Landscaping of front garden to include 3 No. raised beds, pergola & timber summerhouse.

4 Sea Way Middleton on Sea

Thank you for your internet representation made on 23rd March 2015 which has been recorded as '**no objection**' with the comments as follows:

Project: Bespoke building			
FLOOR PLAN Summer 17/18			
Drawn By: J Shepherd	Drawn Date: 13/01/15	Checked By:	Checked Date:
Scale: 1:30	Sheet Size: A4	Sheet Number: 1 of 1	
Drawing Title: Norfolk 16x6g AS DRAWN SHIP LAP			
Drawing Number: sq1018			Rev: A

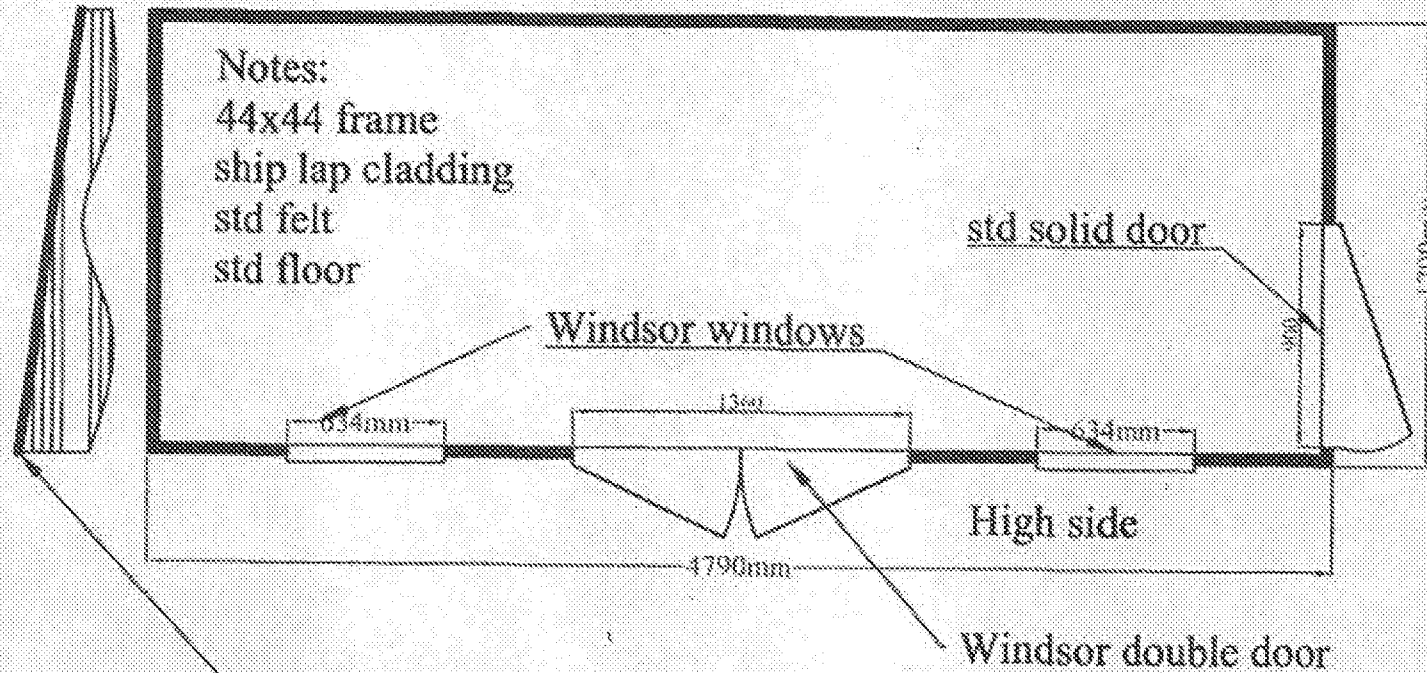
We would suggest the summer house is repainted in a more subdued colour, to be in keeping with the character of the estate, in accordance with VDS.

We request that a appropriate condition applies, if ADC approve this application.
